# HCCD STAGE 1A

## SSD RESPONSE

## HCCD STAGE 1A

DRAWING: GROUND FLOOR AREA PLAN

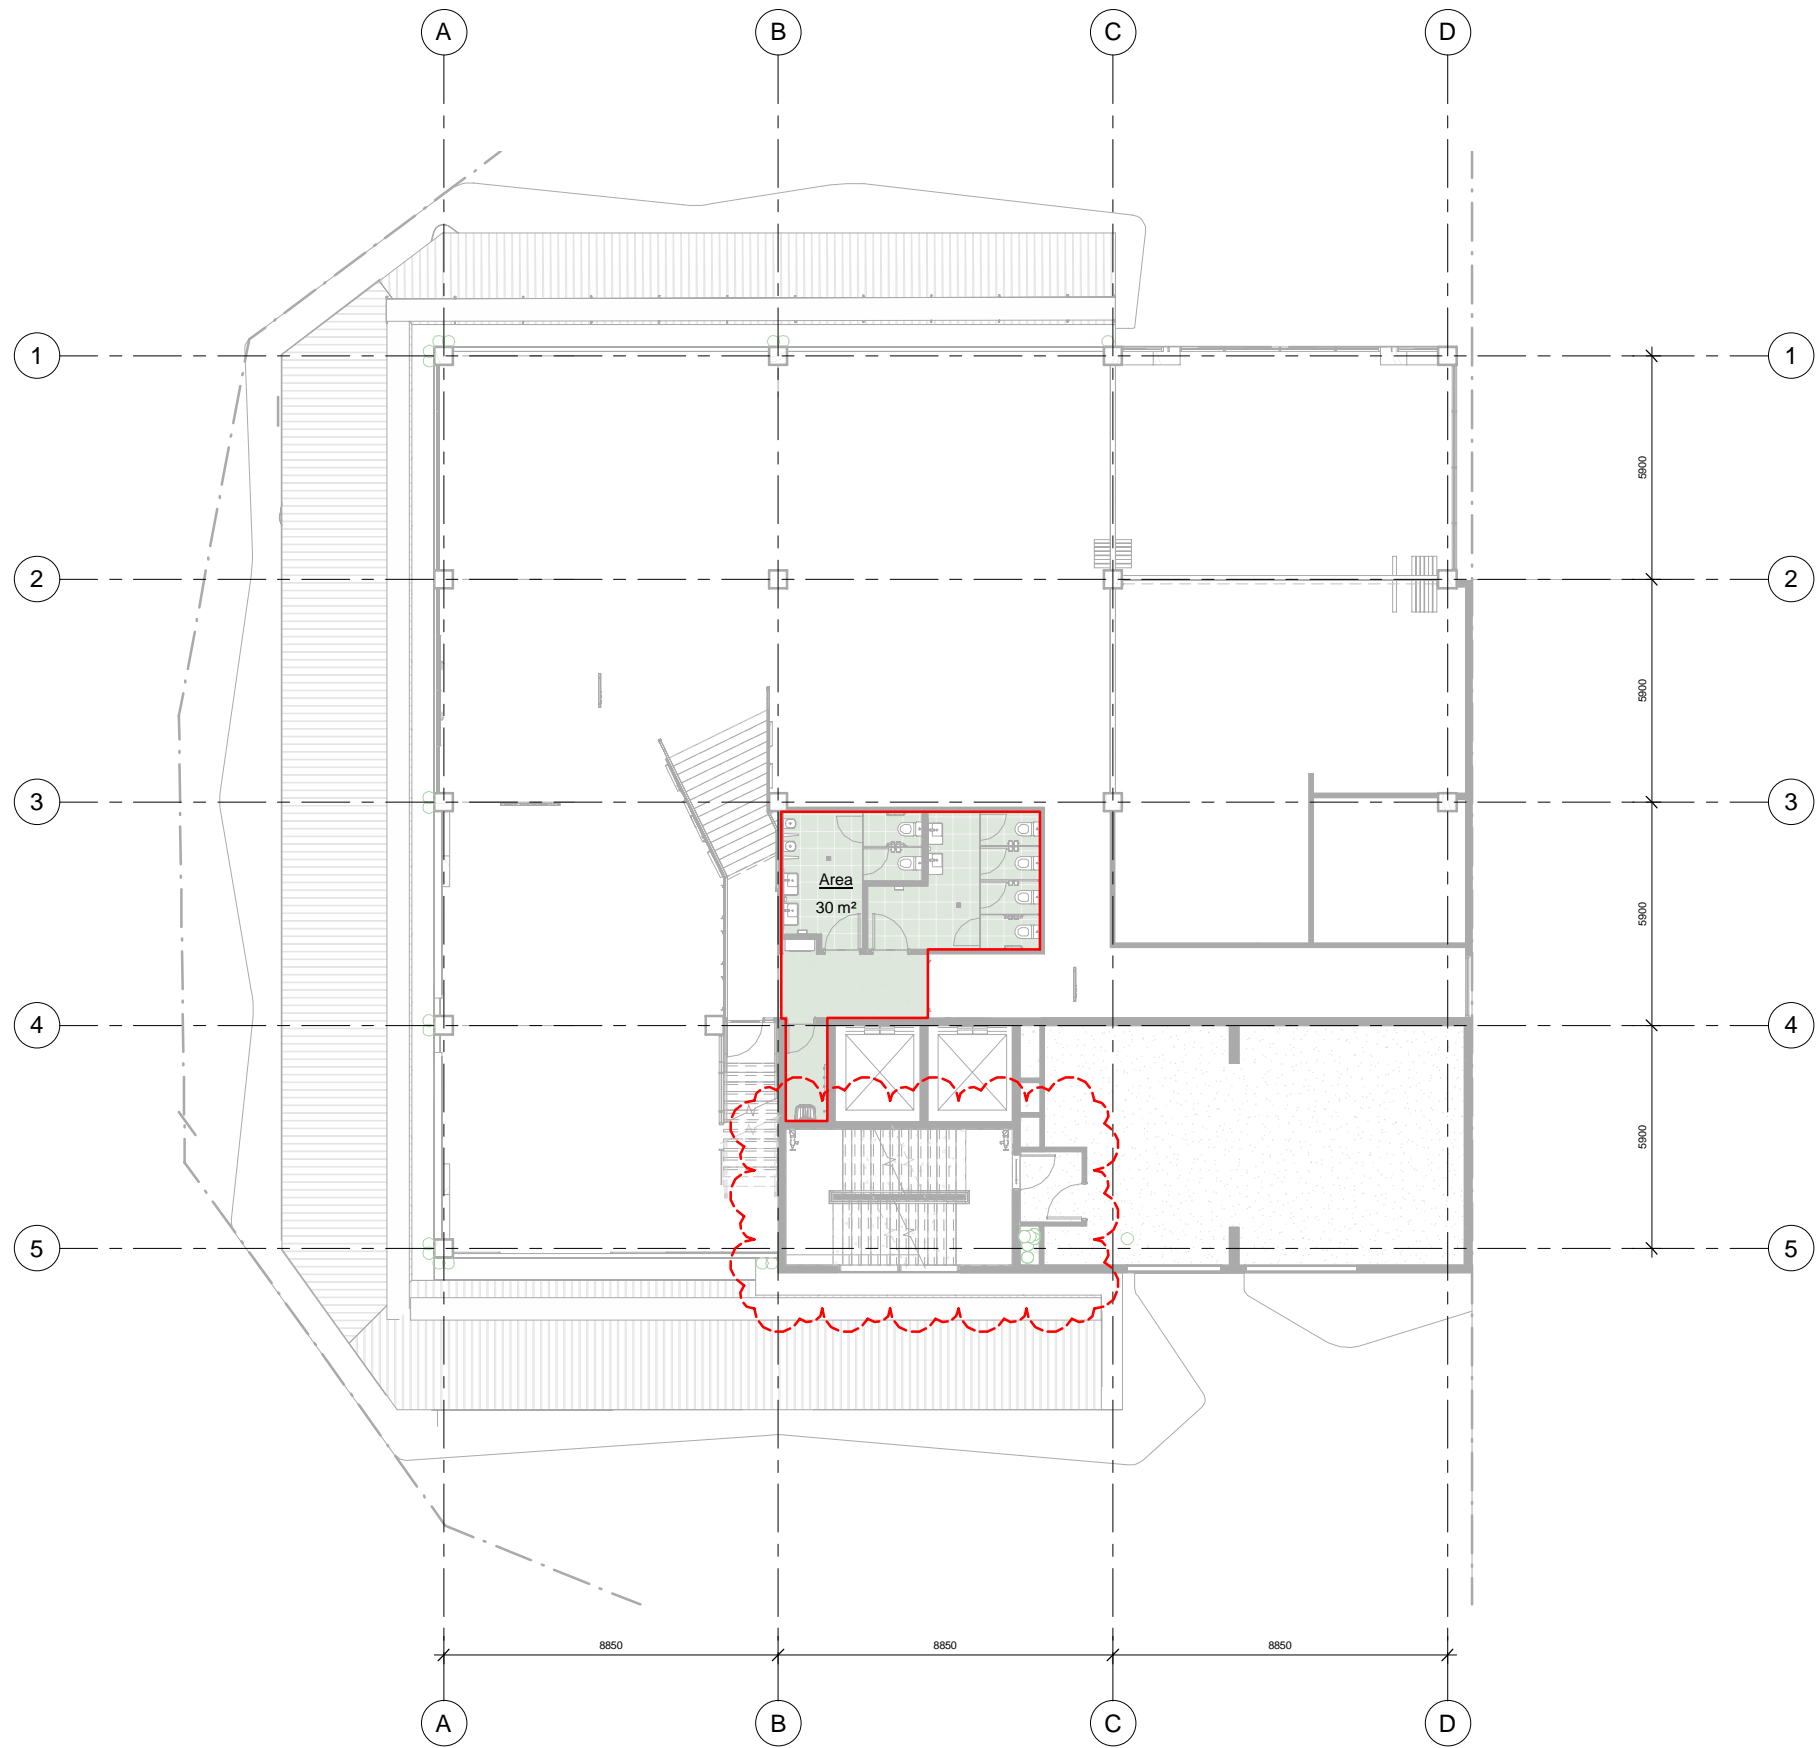
*The position of the main entrance on the west, mid-block, and the 'back of house' south façade is problematic if this is the main approach from the light rail and city, and the university spine. The interstitial spaces, such as the corridor connecting 1A and 1B at ground, are narrow and functional, and do not facilitate the informal interaction that these spaces should typically afford in a university.*

The ground floor program has been shaped around a central vertical circulation core located on the central southern grid bay, providing for uninhibited future proofed emergency egress, and negating legacy issues for the adjacent Site 1B via rights of way or similar.

The residual ground floor space wraps around the core and affords all facades with physical access and exposure via doors and operable glazed walls. In addition, it provides for a flexible use of the space beyond the current brief, including future access points and the ability for the ground floor to address the future development of the HCCD including public domain and adjoining and adjacent buildings as it evolves.
